Application number: 2026/91912	
What is the application for?:	Removal/variation of conditions 2 and 3 (plans) on previous permission 2023/9296
Address of the site or building:	rear of, 271, Cliffe Lane, Gomersal, Cleckheaton, BD19 4SB
Postcode:	LS11 8PG

Type of comment: An objection	
Do you wish your comments to be published on the website anonymously?	No

I write as the owner of 'Bawson Cliffe', the property which directly adjoins the proposed development site. Whilst I understand that the general planning application for this development has already been passed, I wish to address certain aspects of this new application regarding the proposed change to the access point.

Planning Site Layout

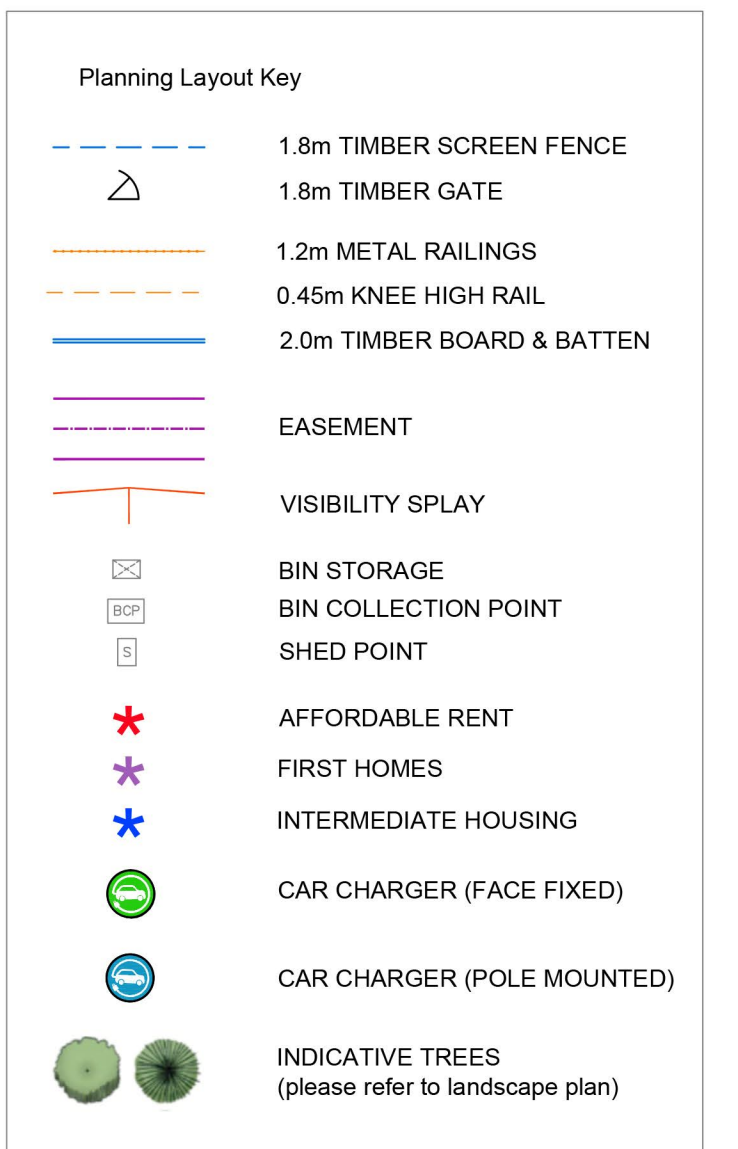
It would appear from these new access plans that - in addition to the pavements to be constructed either side of the access road itself which swerves off to the right - an additional new pavement is to be constructed which will run immediately alongside our privately owned boundary wall. Presumably this new pavement is to take the place of the current public footpath/right of way.

- 1) Any proposed excavation and paving poses a risk to the structural integrity of our boundary wall's foundations.
- 2) Any proposed excavation and paving also poses a risk of damage to the roots of the established trees within our garden located just inside the boundary wall - trees that are protected under TPOs issued by Kirklees Council. Any pavement construction involving digging runs the risk of cutting through and compromising the Root Protection Areas (RPAs) of these protected trees which can result in either killing or destabilising them. (I understand the RPA to be calculated at 12 x diameter of the tree trunks).

I would kindly request that the Planning Dept requires the developer to submit a certified assessment demonstrating how the protected trees will remain unharmed as well as a structural method statement proving that our boundary wall will not be undermined during or after construction. Otherwise, that an adequate buffer zone be provided.
